23/01586/REM Himley Village Phase 2A – Amended Submission
Urban Design Comments
Nick Thomas
18th October 2024

This note relates to an amended Reserved Matters Application for Himley Village Phase 2A (planning ref 23/01586/REM). This note should be read alongside:

HIMLEY VILLAGE BICESTER – PHASE 2A – ROWAN CT4

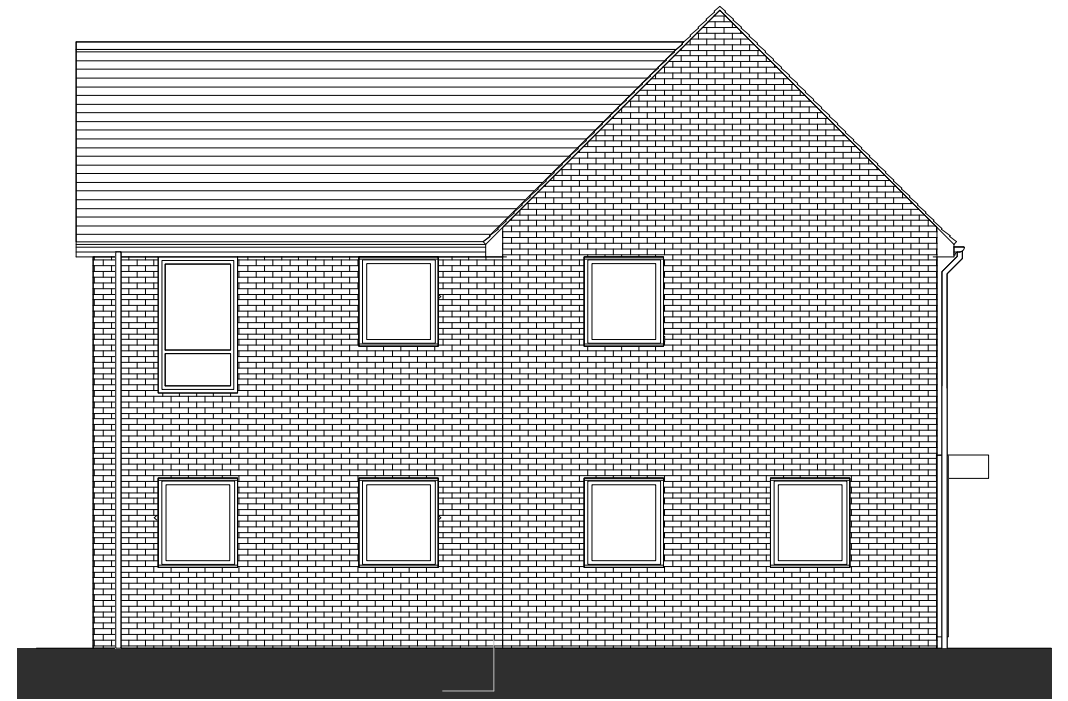
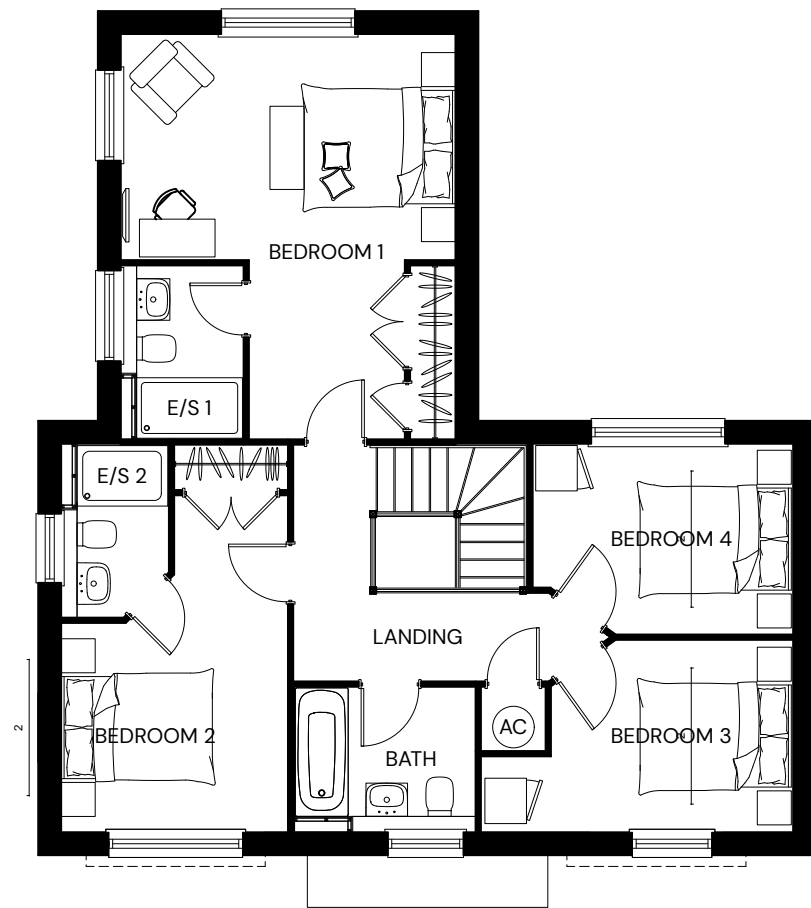
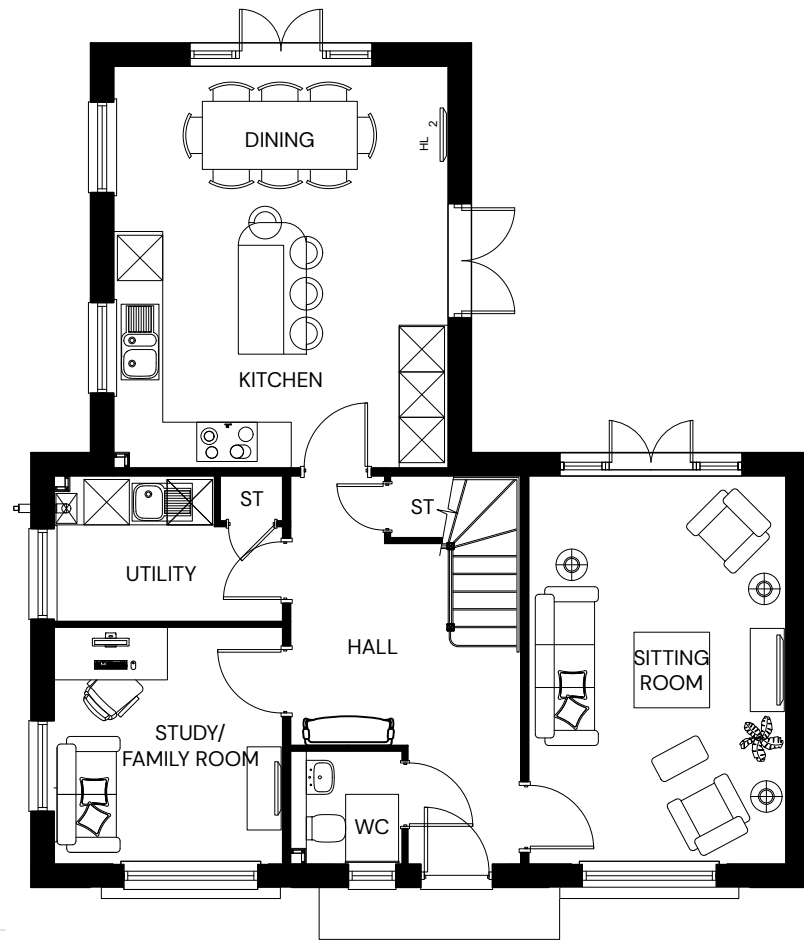
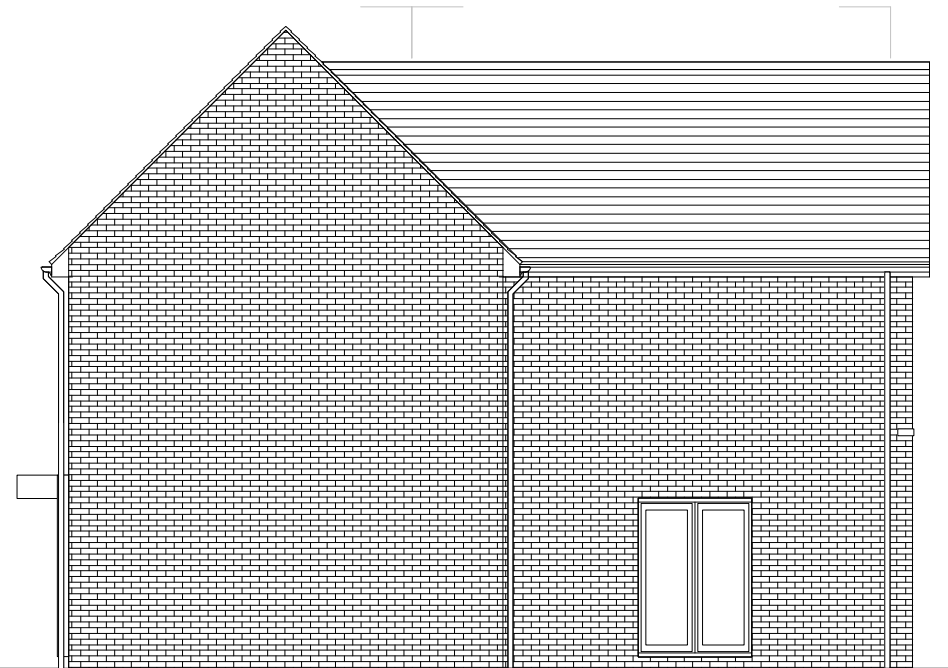
Section CC – Plot 112 (mark-up plan attached)

- Suggest the main house should be brick and the subservient corner turning wing should be weather boarded so that the main house/ subservient wing read as such from the adjacent open space. The use of cladding should be used honestly in the design rather than for superfluous decoration.

HIMLEY VILLAGE BICESTER – PHASE 2A – TULIPWOOD ELEVATIONS CT1

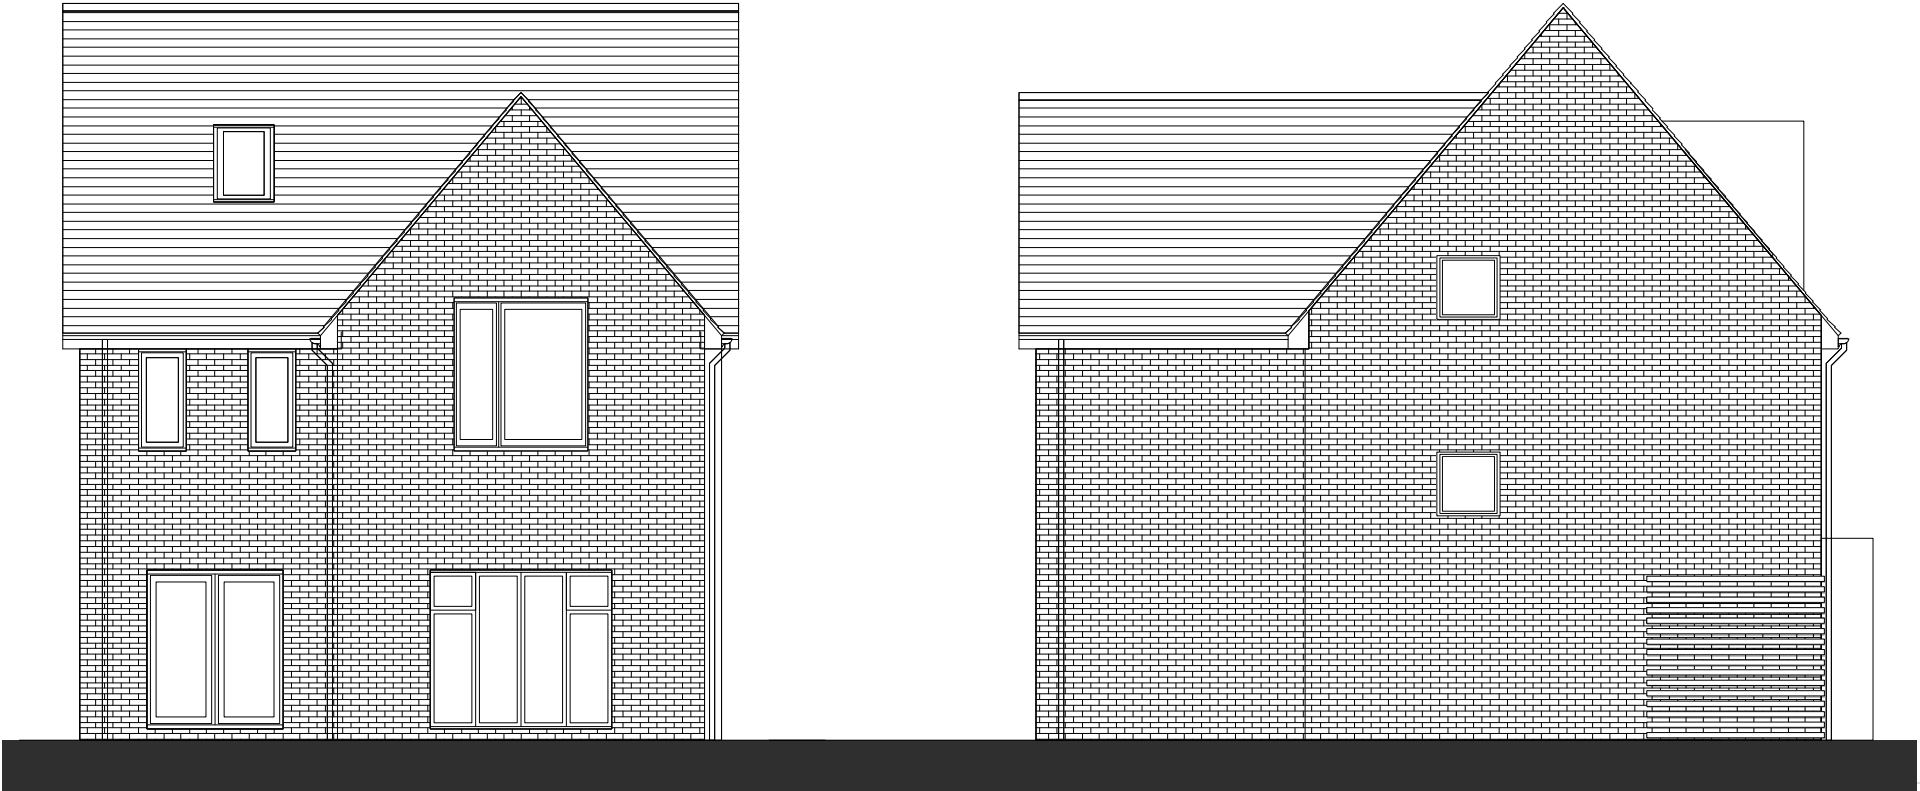
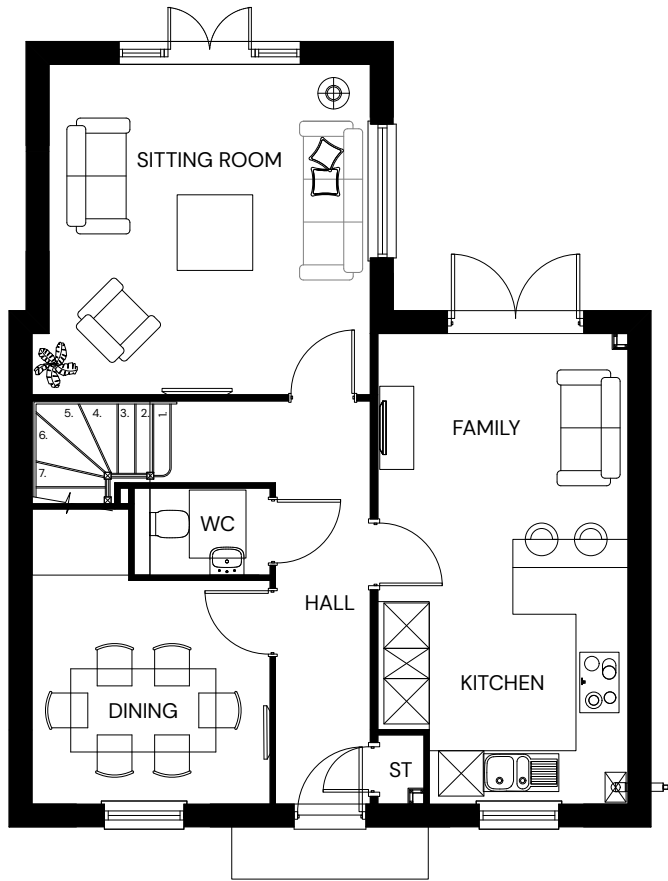
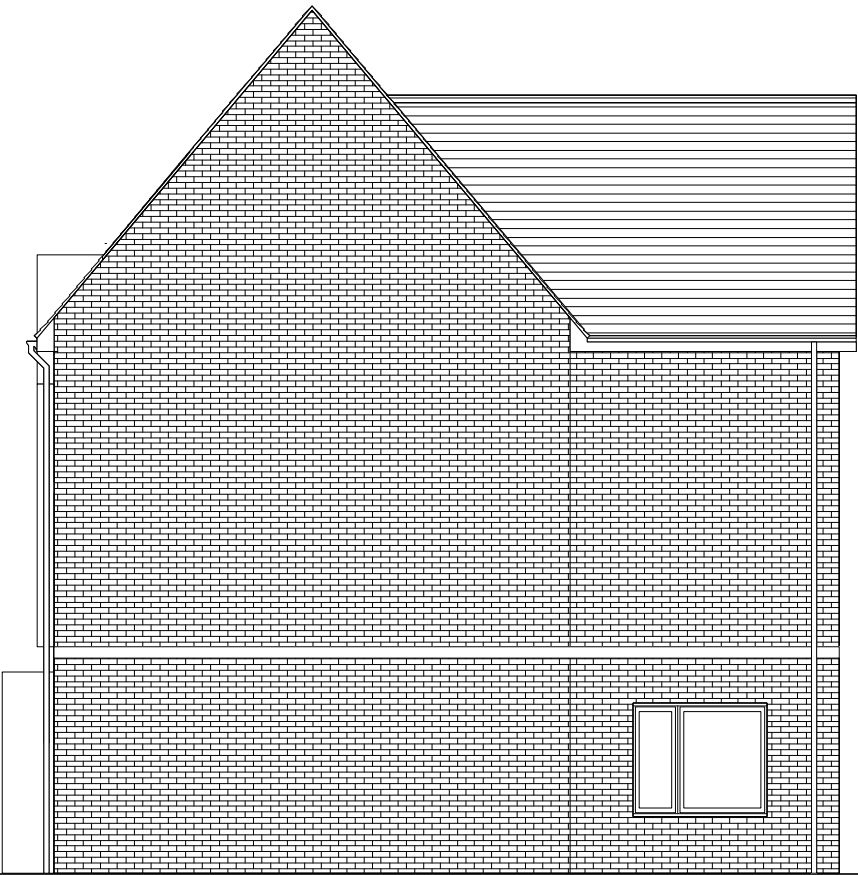
House Type – Tulip Wood CT1 and Tulip Wood CT1 Key Corner

- A rooflight is proposed to the front elevation. Rooflights are not acceptable on the front or principal elevation (Design Guide SPD, p114).

HIMLEY VILLAGE BICESTER - PHASE 2A - HEATHER (GABLE) CT3

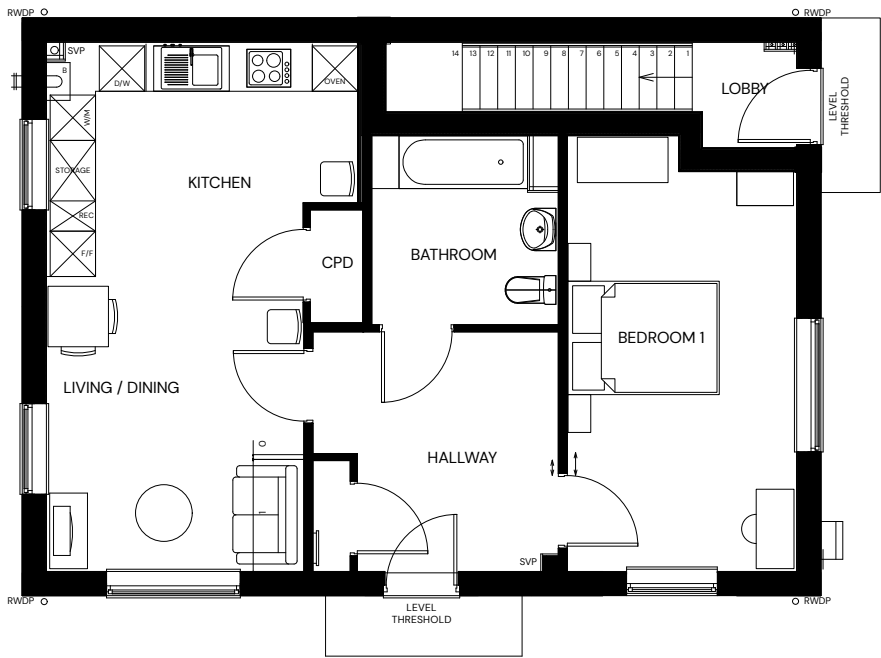
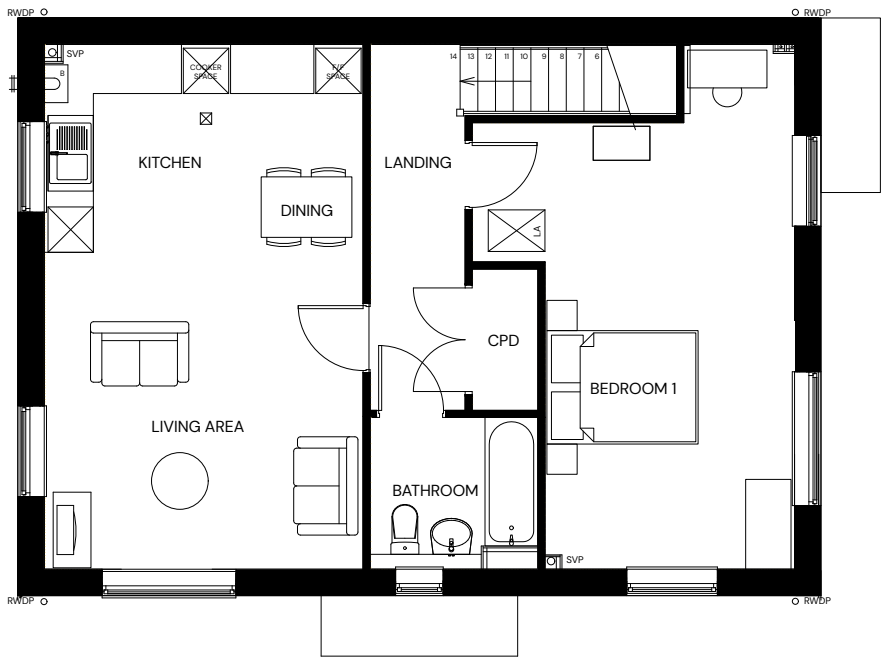
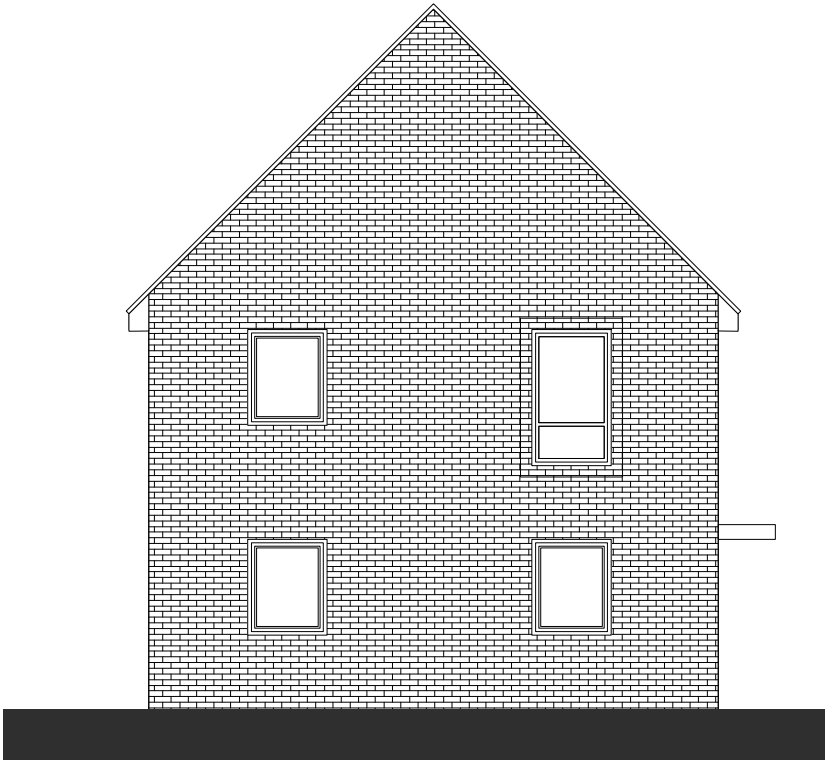
Section BB – Plot 66 (mark-up plan attached)

- The exposed gable end would be visible from the wider countryside/proposed local centre. Exposed wide gable ends are uncommon in Cherwell and should be avoided (Design Code SPD, p.95)
